PLANNING BOARD REPORT PORTLAND, MAINE

MMC Congress Street Hospital Building
22 Bramhall Street
Level III Site Plan
Project #000331-2018
53-D-7
Maine Medical Center, Applicant

Submitted to: Portland Planning Board Public Hearing Date: December 17, 2018	Prepared by: Nell Donaldson, Senior Planner Date: December 14, 2018
---	--

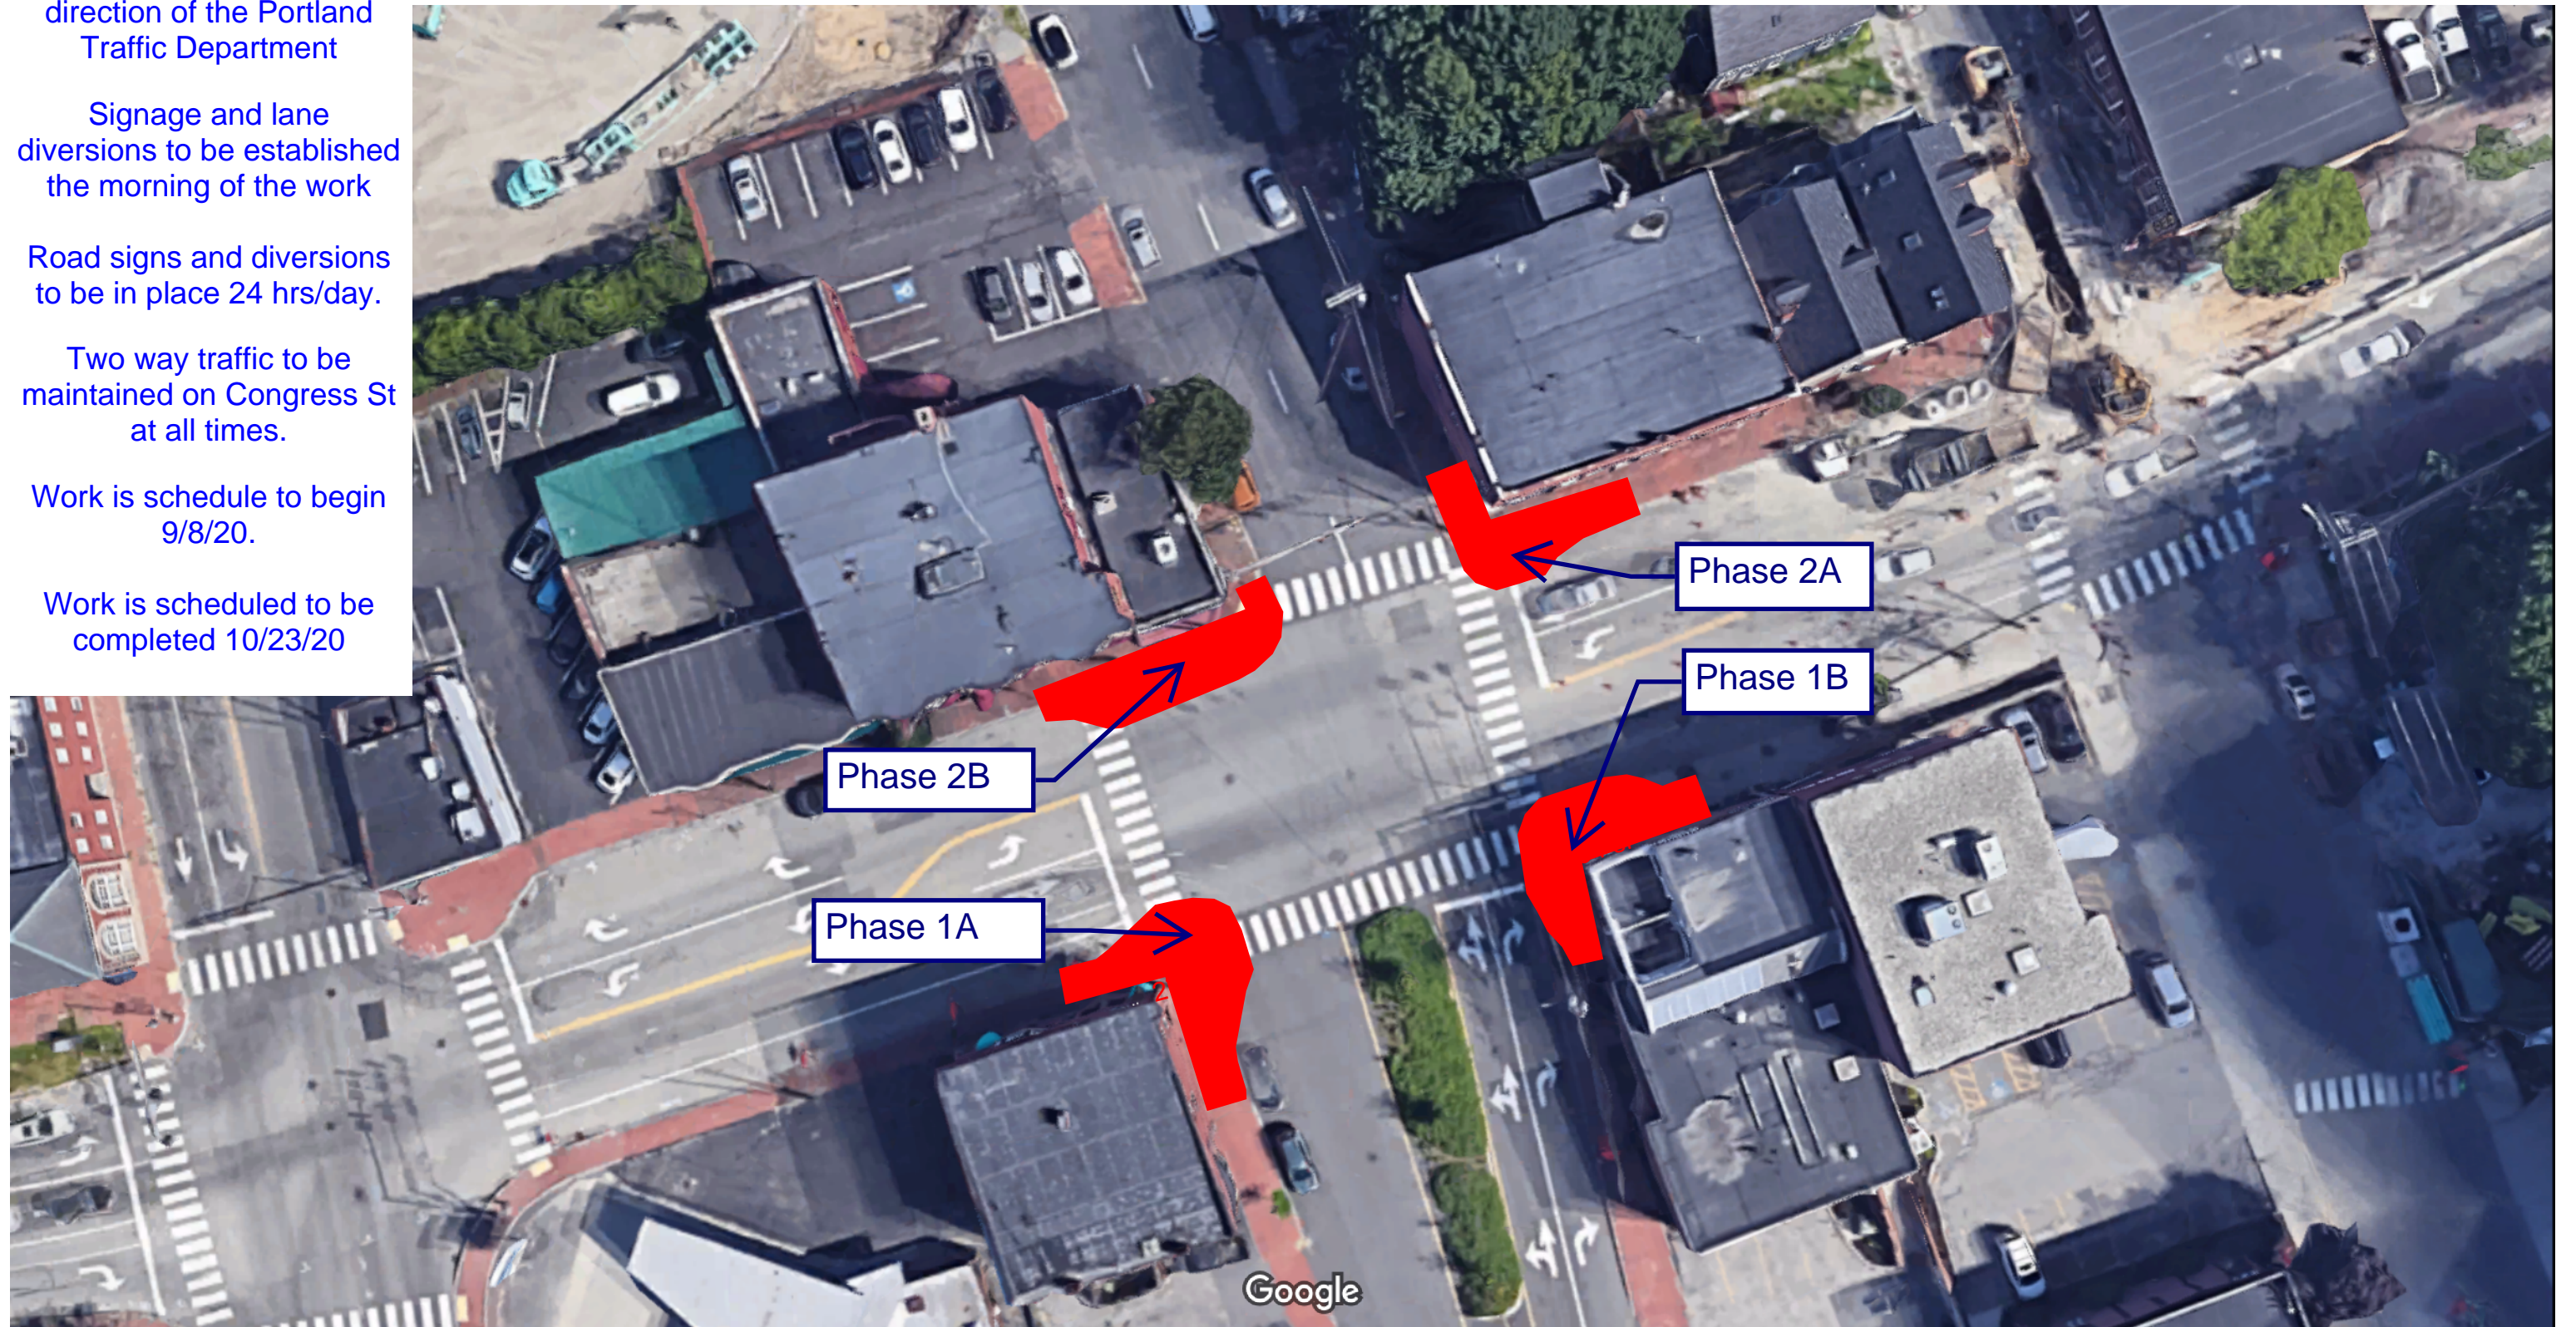
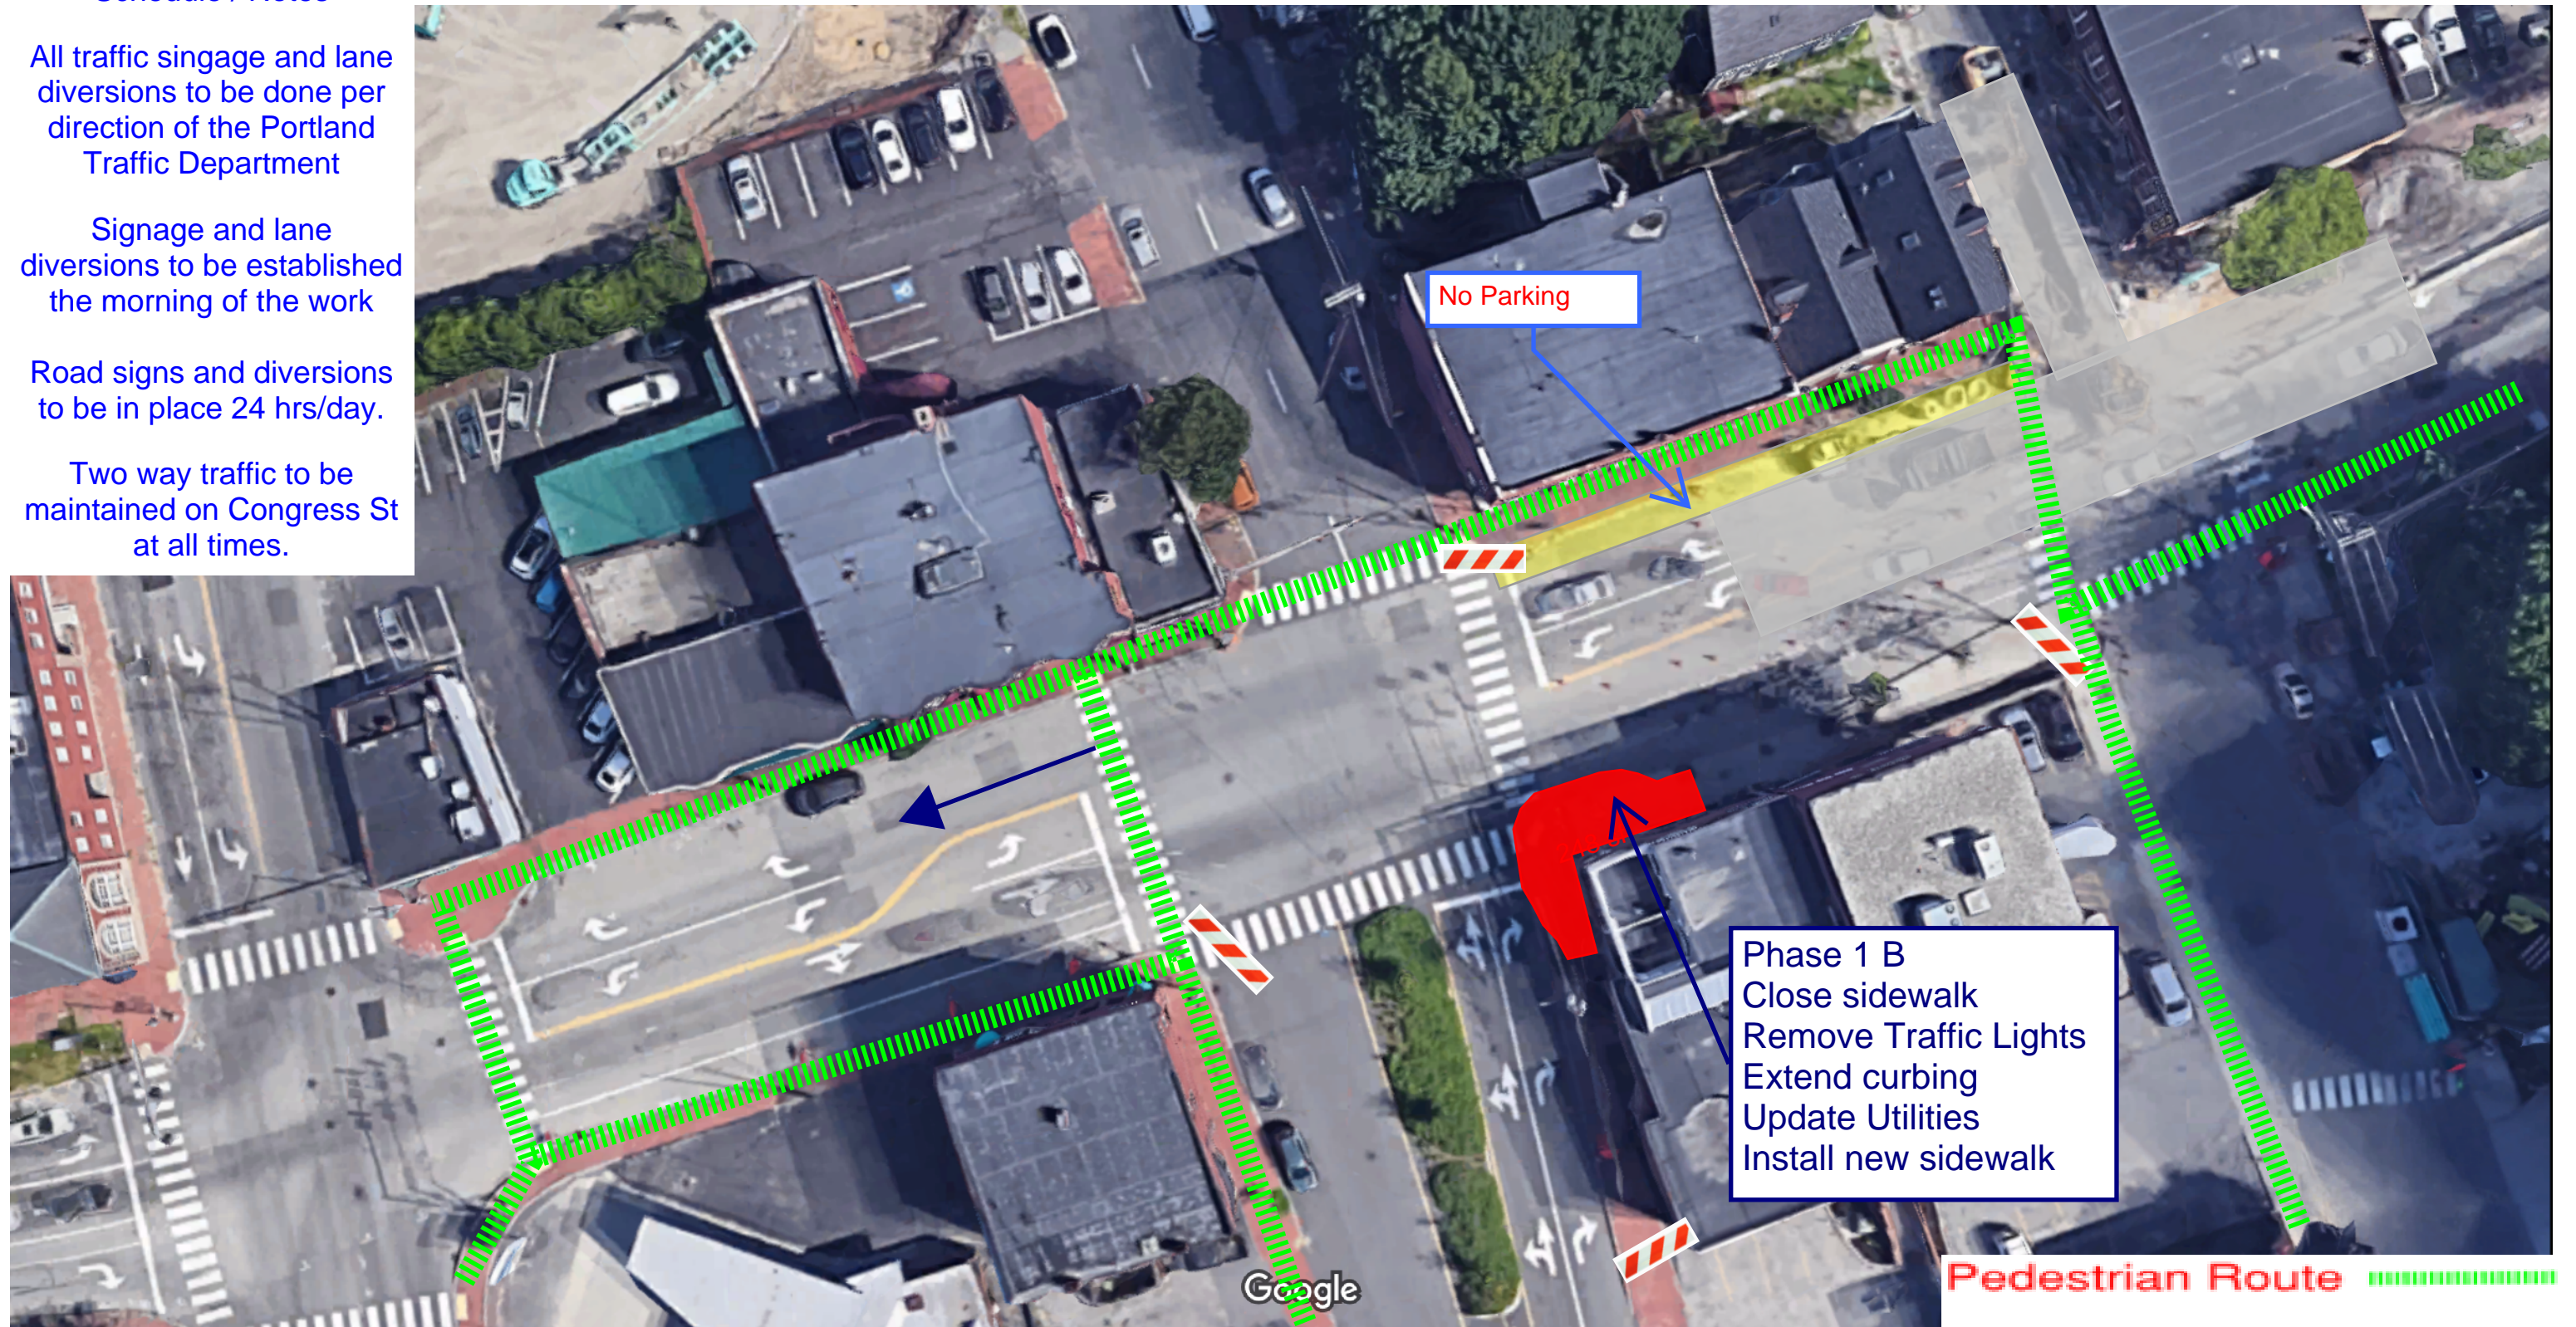
It is recommended that further discussion on the duration of the Congress Street sidewalk closures be included.

Supplemental pedestrian safety devices will be required during the sidewalk closure time period (to safely cross pedestrians for the sidewalk detour).

All sidewalk detours shall be ADA compliant.

Changes to the lane configuration on Congress Street west of Gilman Street is likely and may need to be included in the plan.

A significant amount of construction activity will be required for utility and street construction work and specific plans shall be development for review and approval.
